### LSC Responses to CDOT Comments

RE: Waterbury Filings Nos.1 and 2 PUD PP - PUDSP215

## Waterbury Filing Nos. 1 and 2 Traffic Impact Analysis (LSC #204220) March 11, 2022

Deviation Exhibit 2  
**Saybrook Drive**  
**Cross Section**  
 Waterbury (LSC #204220)

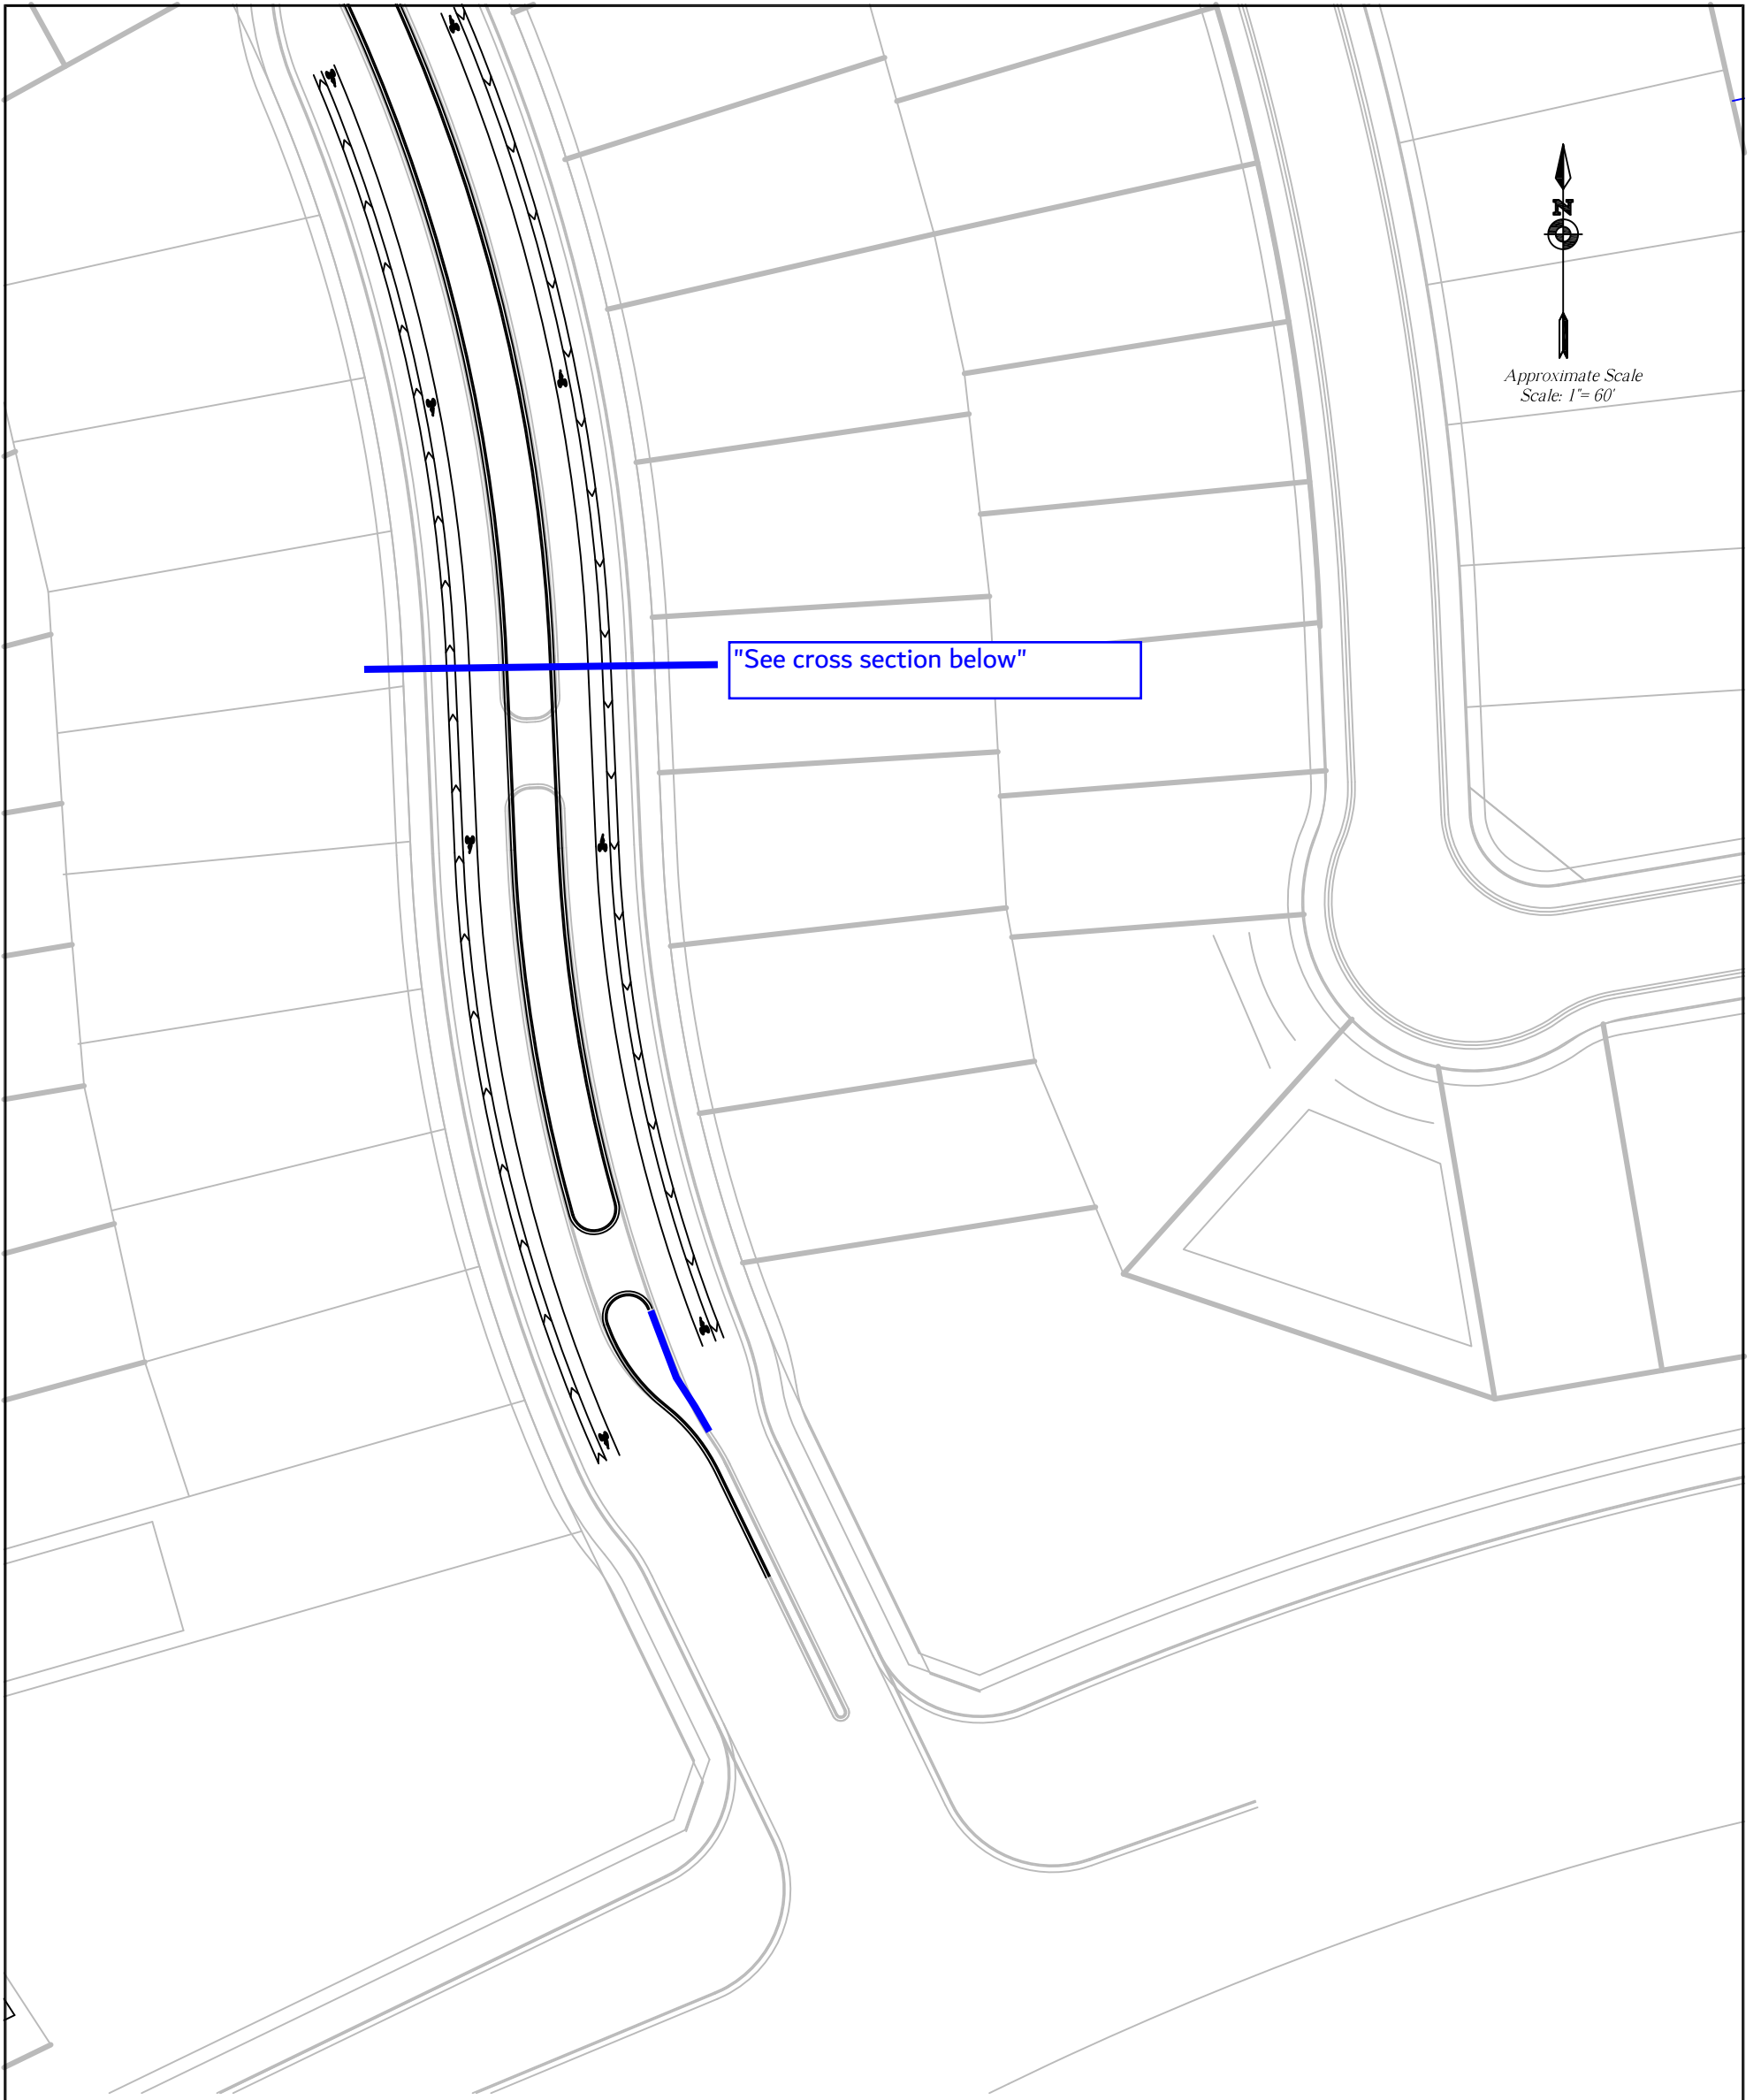
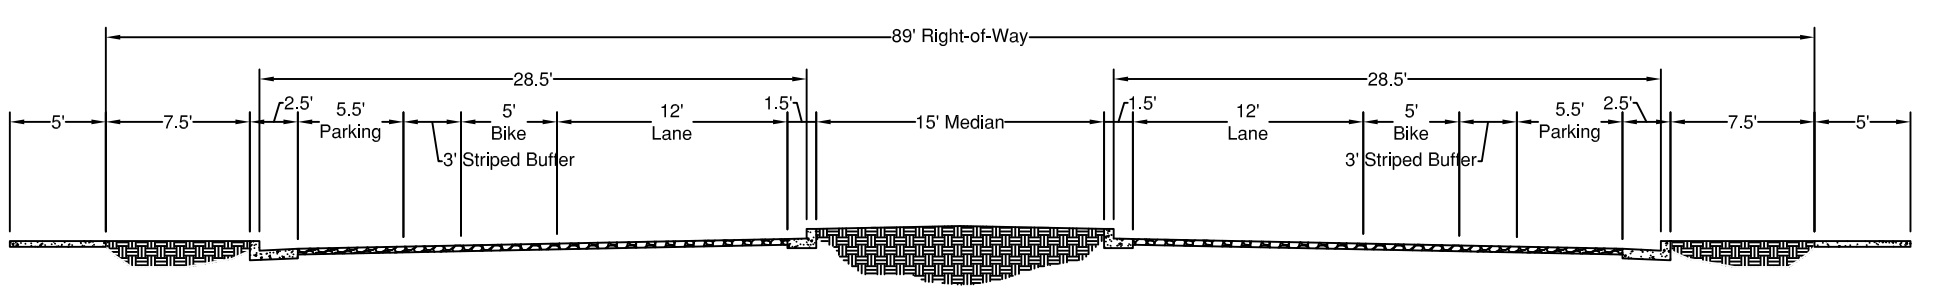
State that Water  
quality will be  
provided (verify)

State that Water quality will be provided (verify)

Author: lscja      Subject: Sticky Note      Date: 7/20/2022 11:58:18 AM  
LSC Response: Added as requested.

Recommended Turn Bay Geometry  
Saybrook Road at Stapleton Drive  
Waterbury Preliminary Plan No. 1

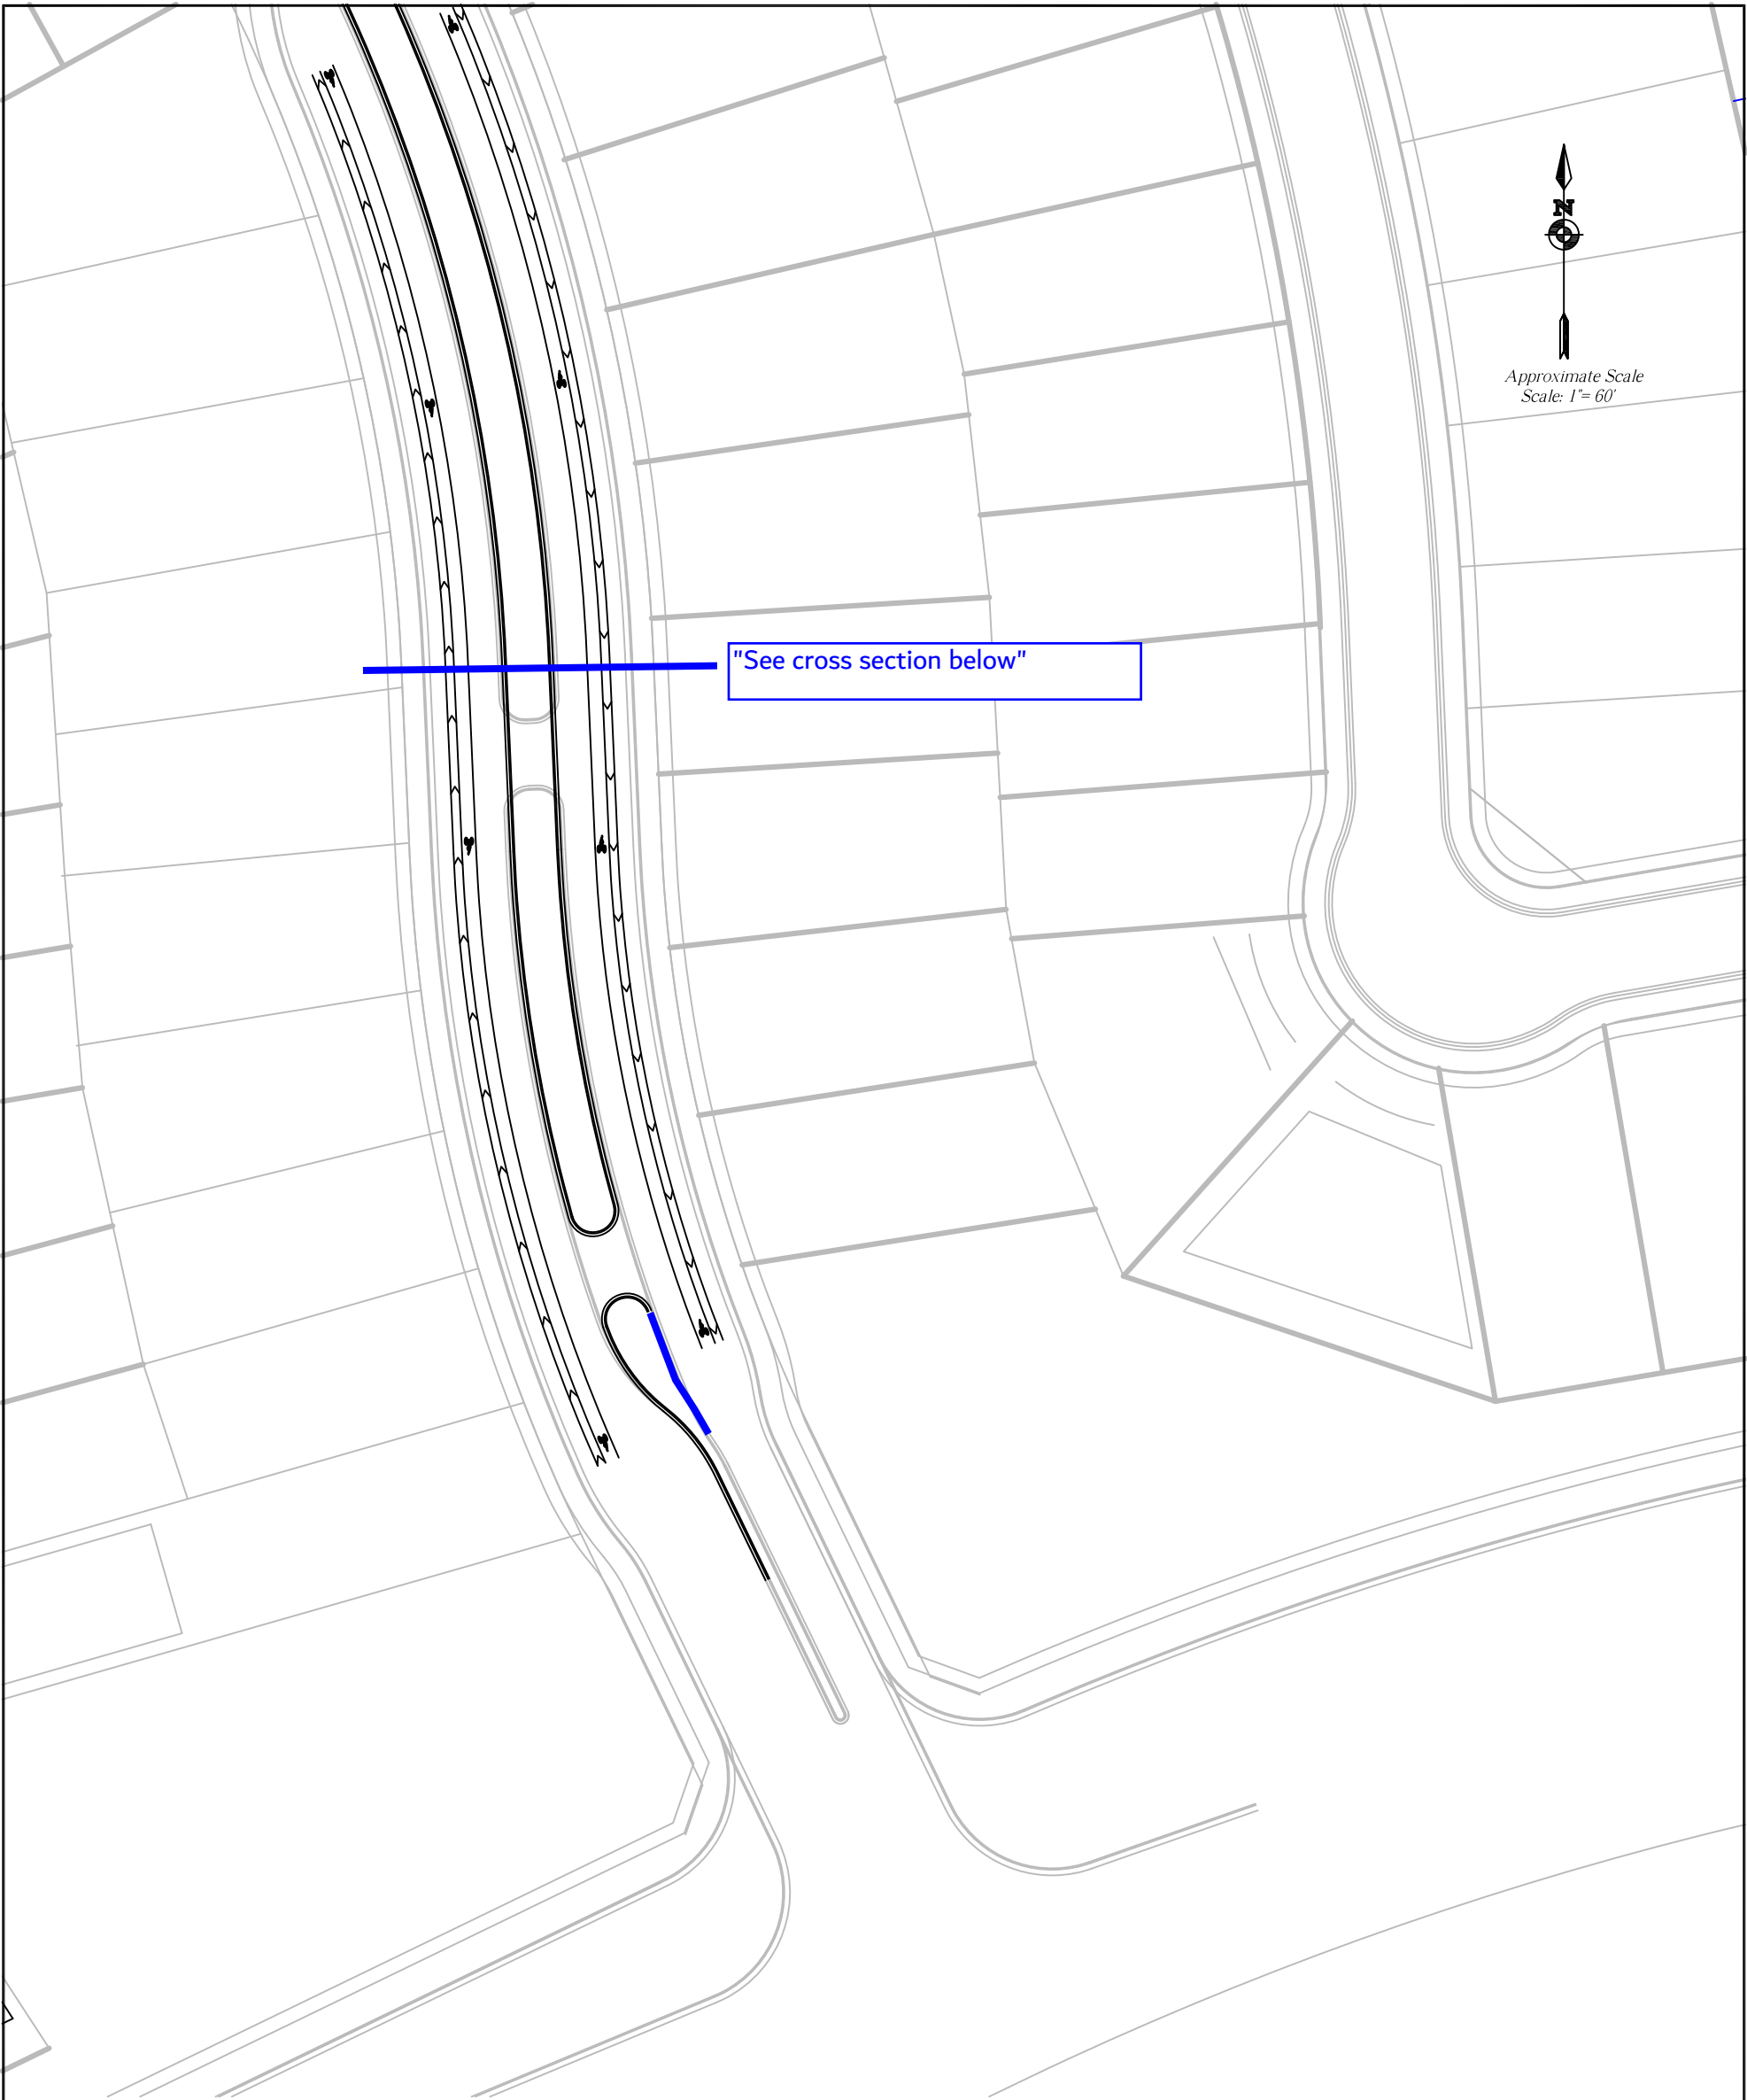
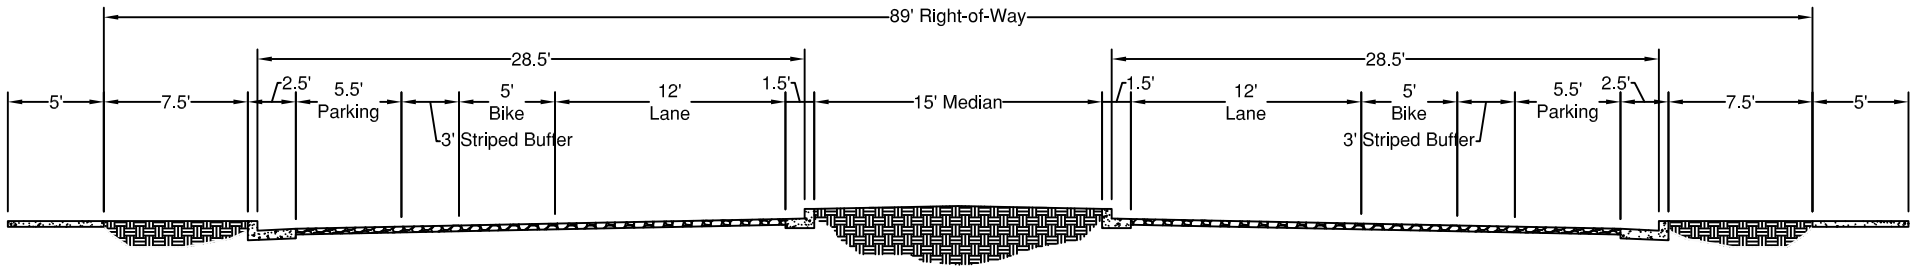
Need to state what part of the ECM  
the deviation is being requested for.

Need to state what part of the ECM the deviation is being requested for.

[For a total right turn length of 285 to 310 feet](#)

[for a total left turn length of 285 to 310 feet.](#)

LSC Response: Added as requested.

LSC Response: This paragraph has been revised in the updated deviation.

LSC Response: This paragraph has been revised in the updated deviation.
